Our Ref: AWE200083-L01: BCP/bcp
Contact: Dr Brett C. Phillips

22nd February 2021

RESPONSES TO FLOODING SUBMISSIONS, ASPECT INDUSTRIAL ESTATE, KEMPS CREEK, NSW

Figure 23 100 yr ARI Flood Hazards - Stage 1 Conditions

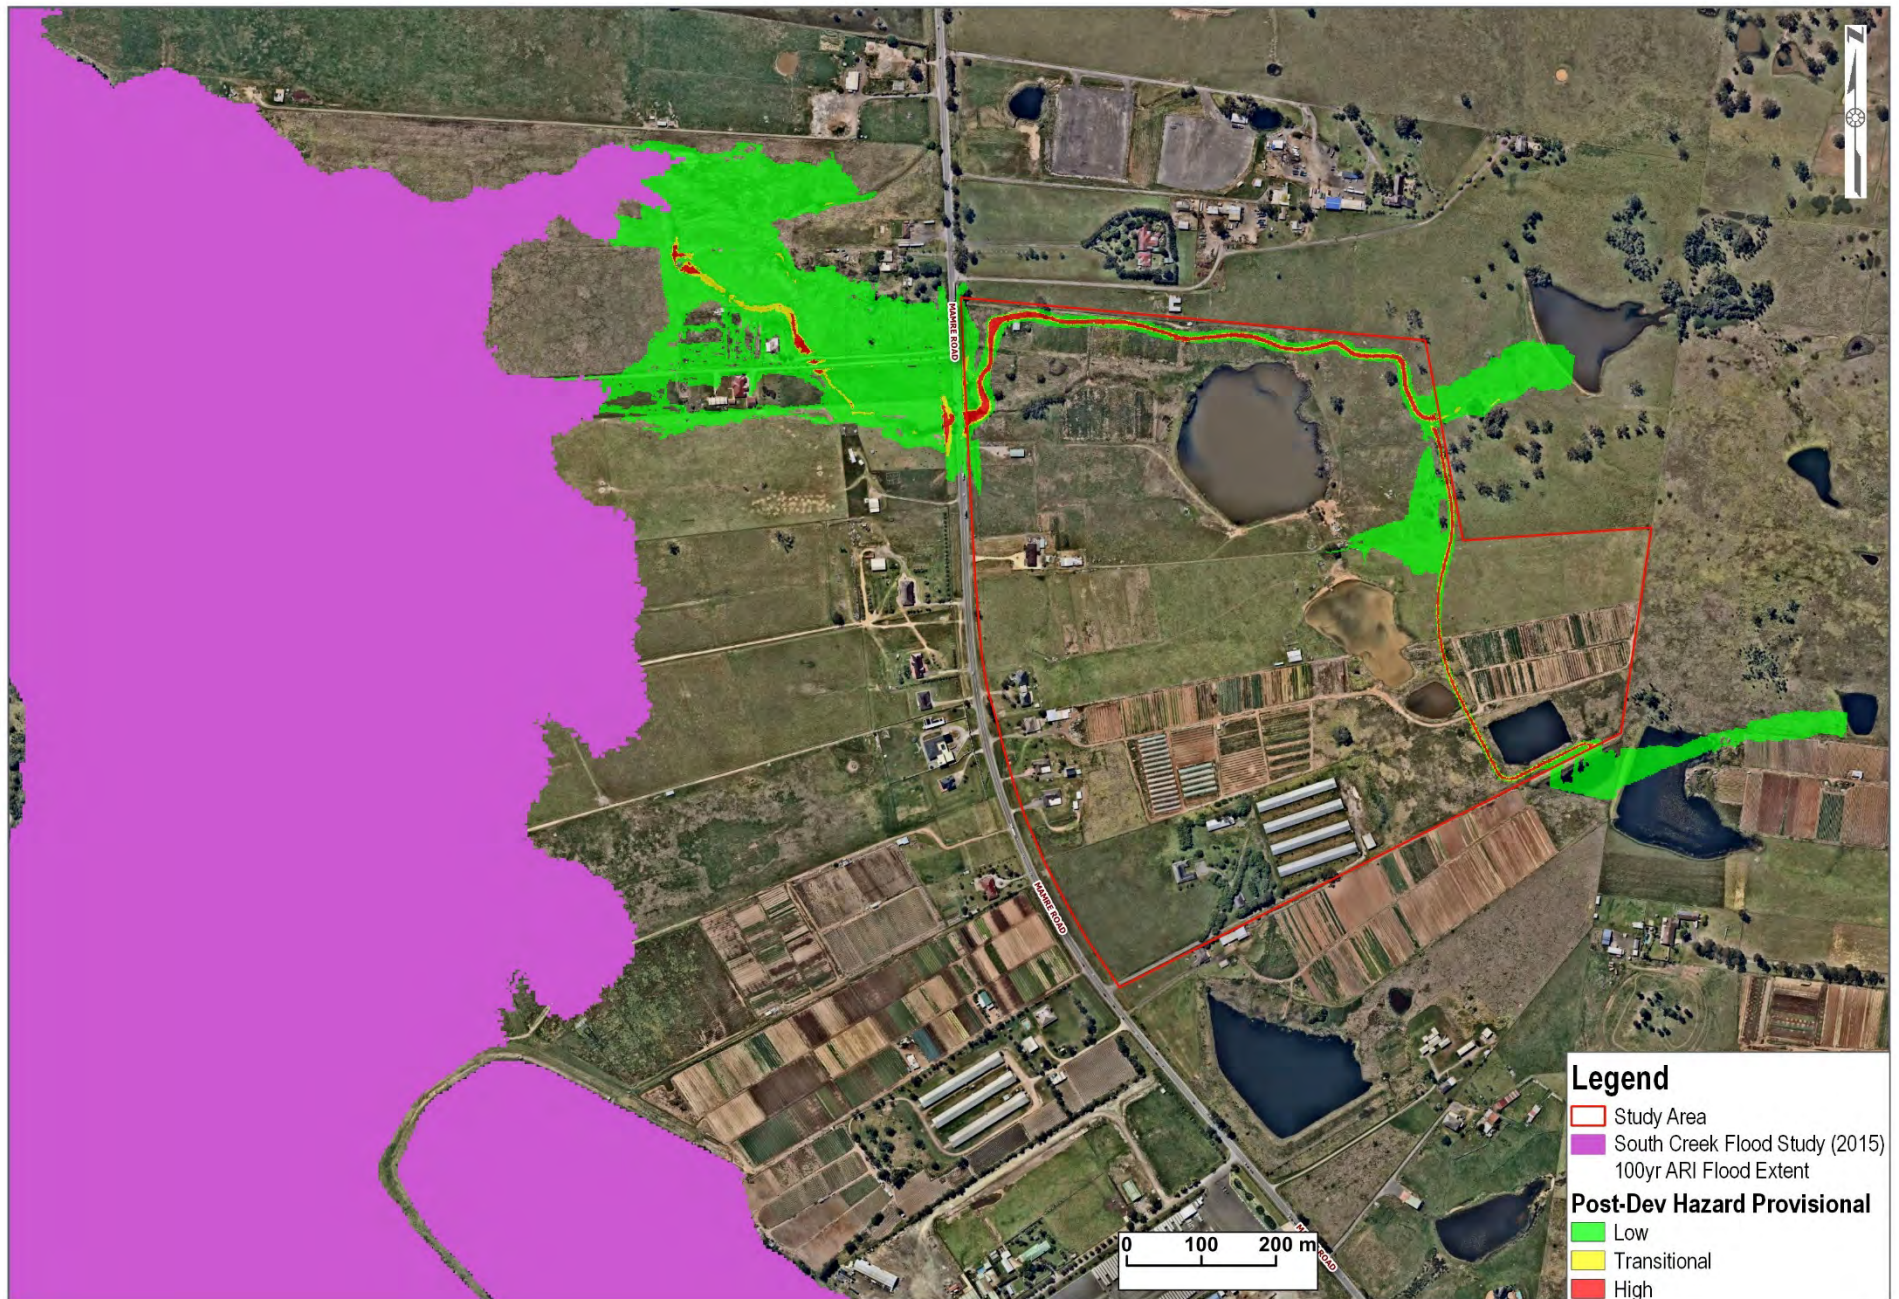
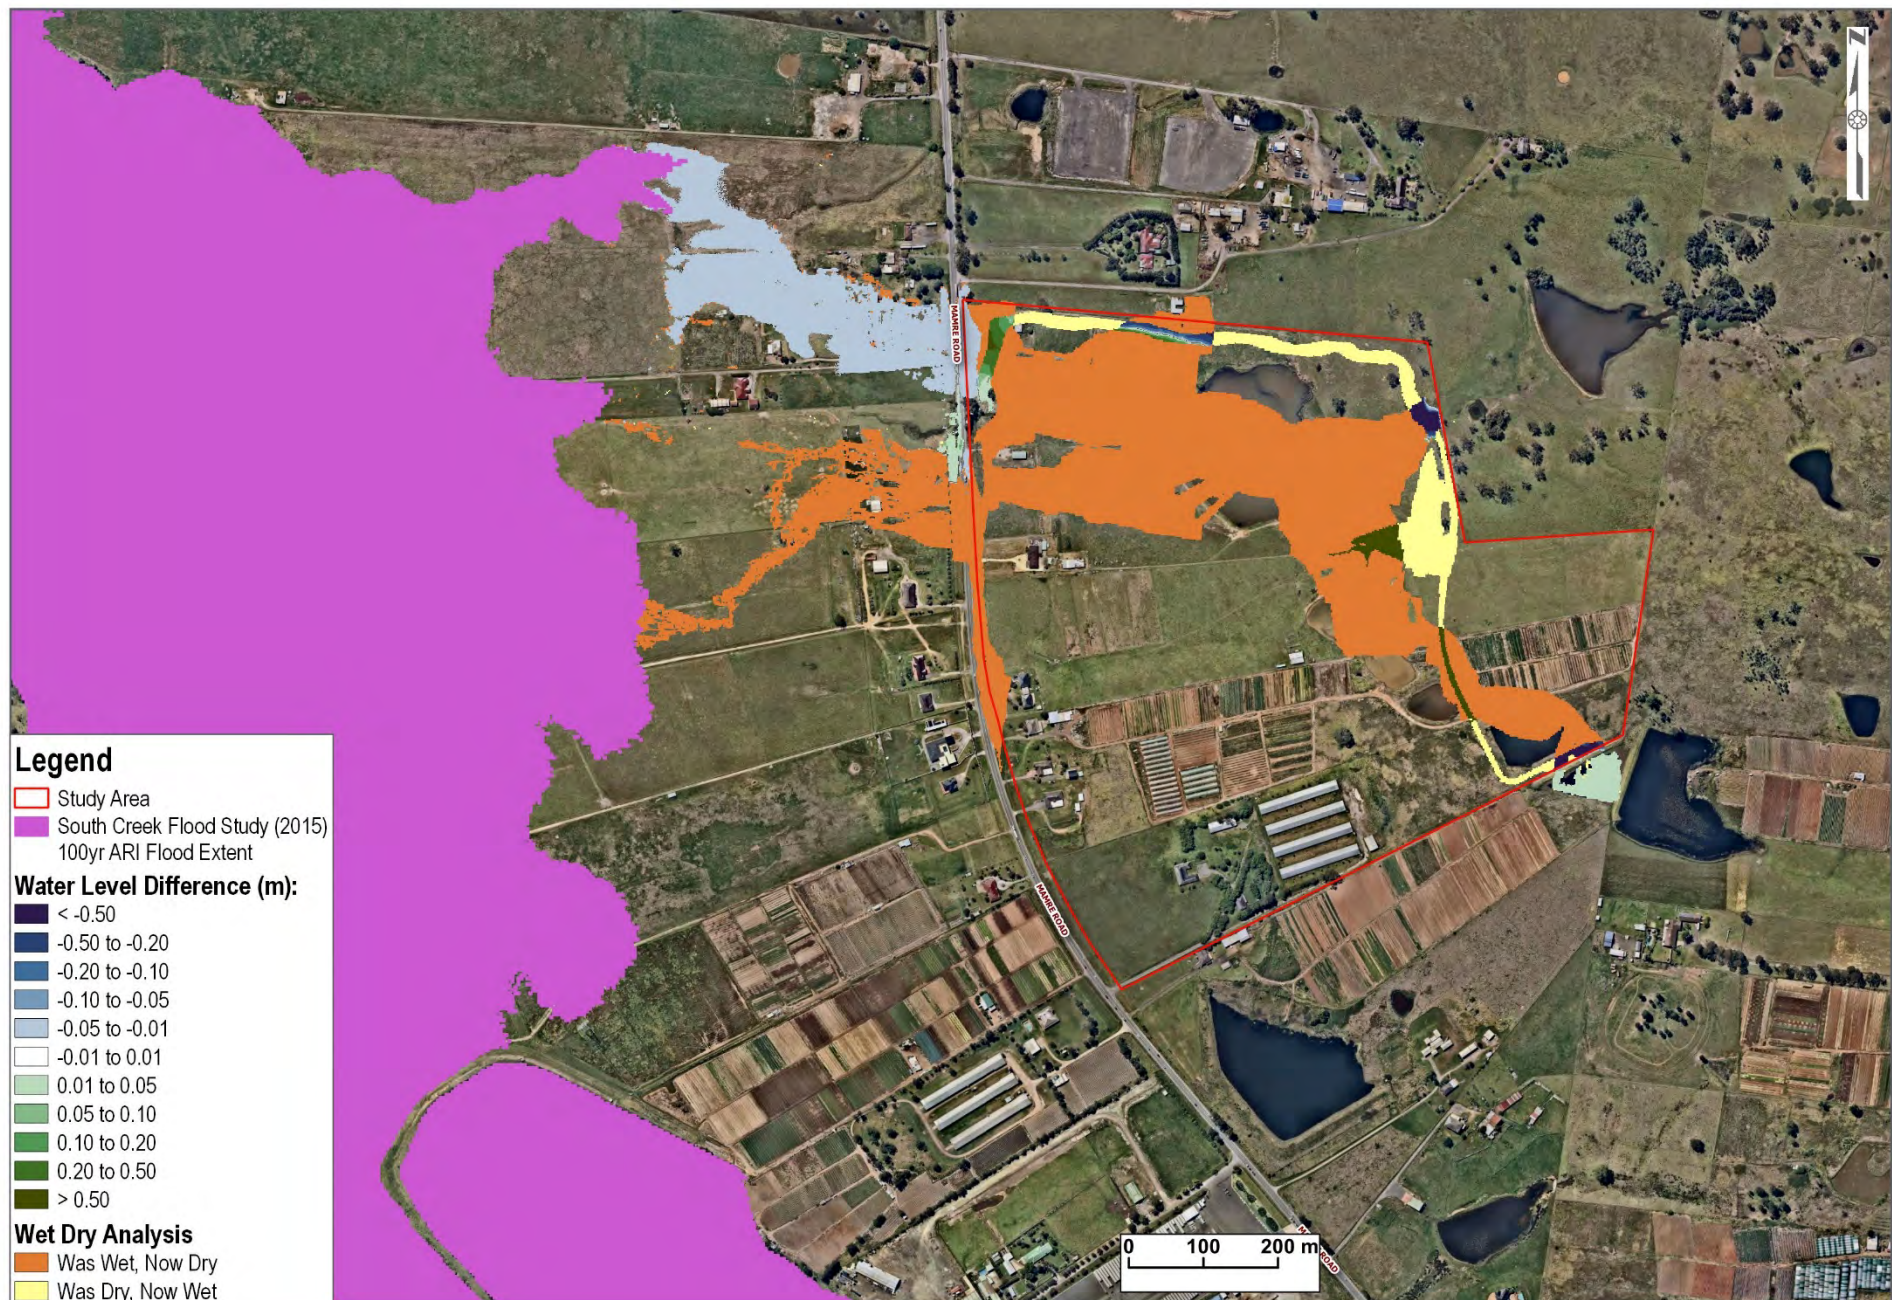
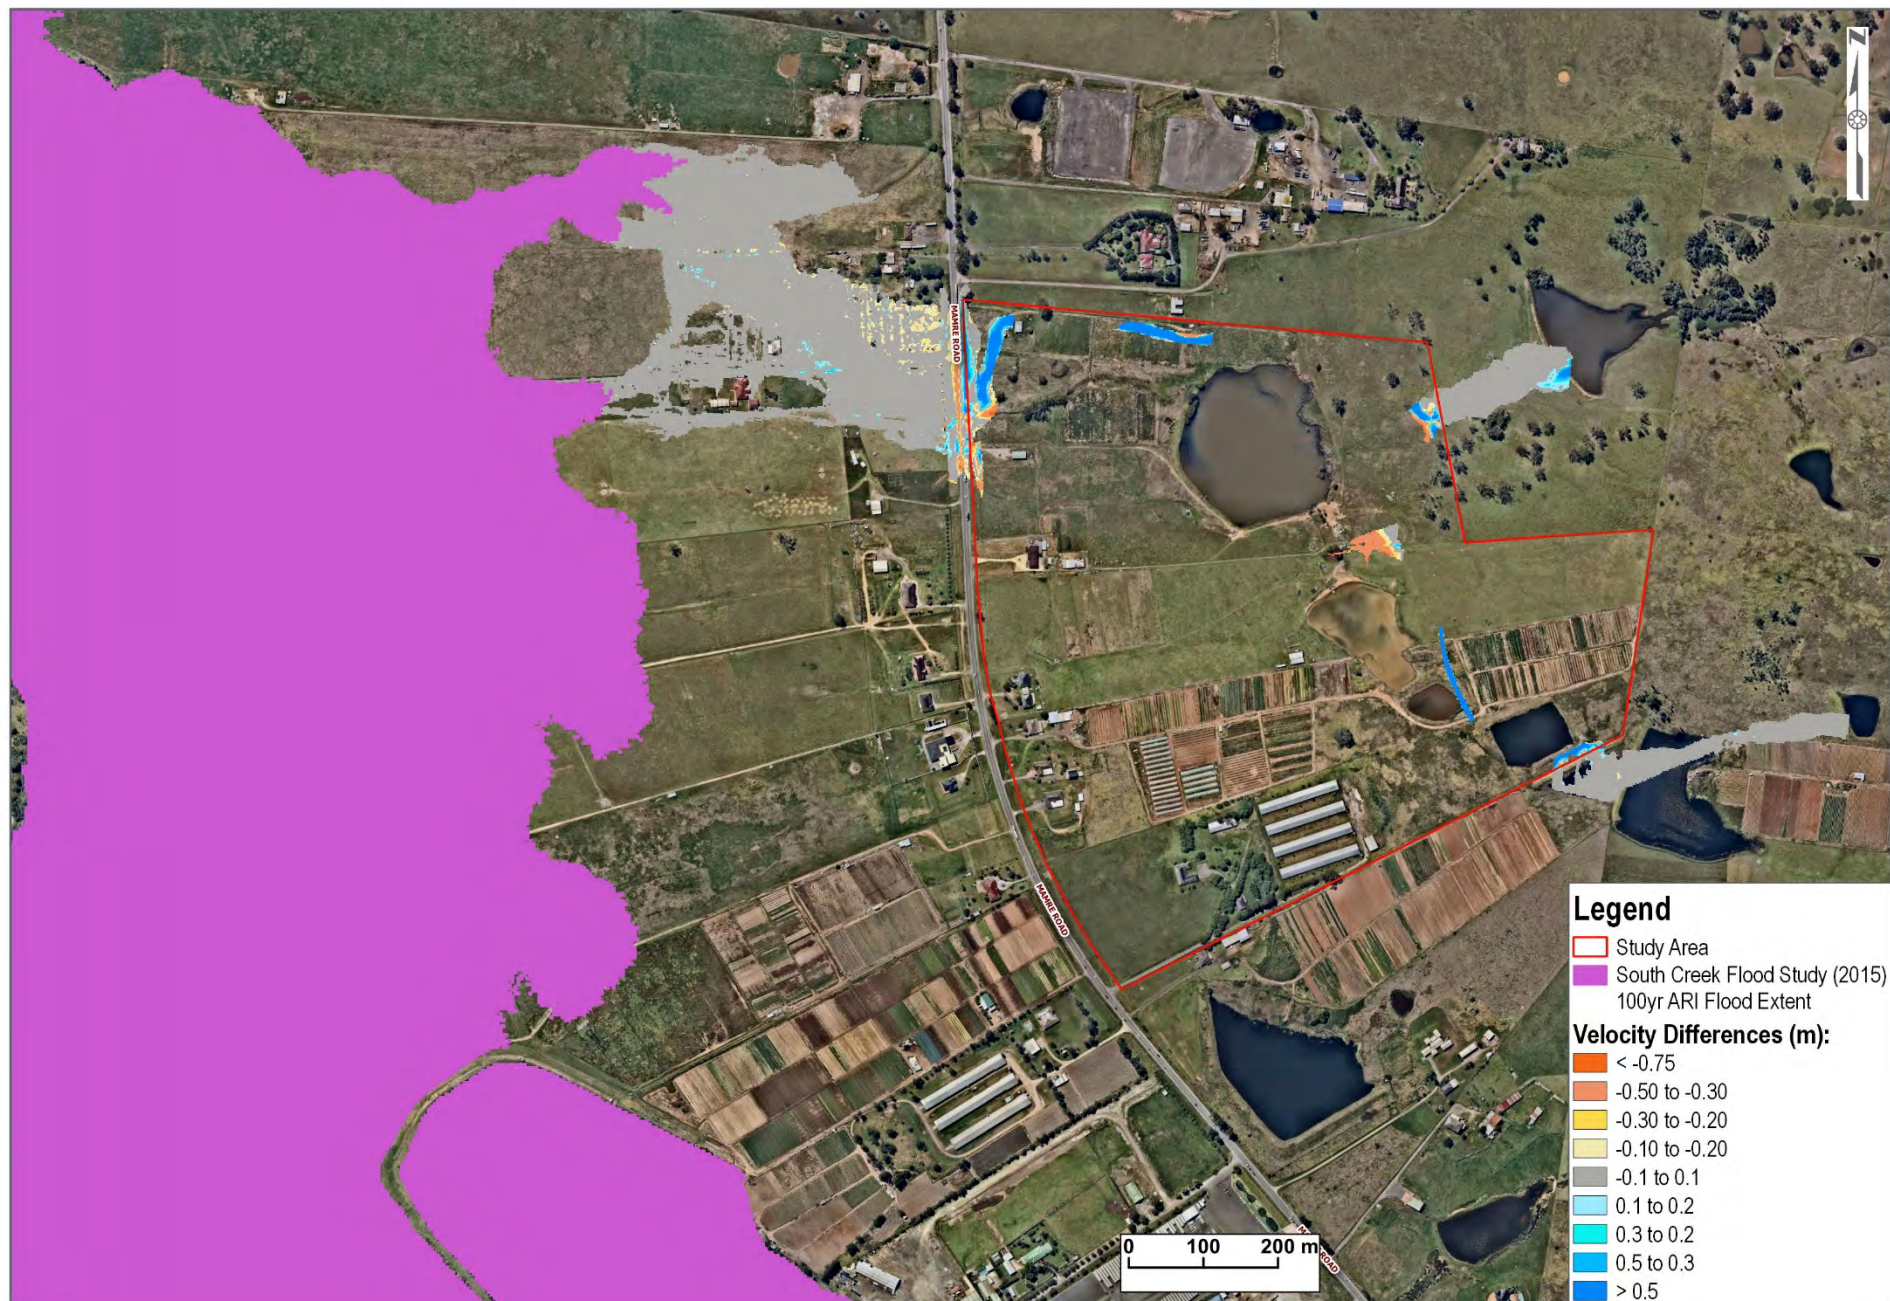
- *The developed scenario maps present local overland flow for Stage 1 which comprises of two industrial lots on the northern part of the site. However, from a flow management perspective, an overland flow study should consider the ultimate developed scenario of the site instead of considering each progressive development independently.*

- *All maps for developed conditions should properly depict the layout of the development, locations of proposed constructed channels and the location of the proposed detention basin.*

The final masterplan has been assessed and the results of the assessment have been incorporated into an updated version of the FIA report.

The updated Figures have been incorporated into an updated version of the FIA report.
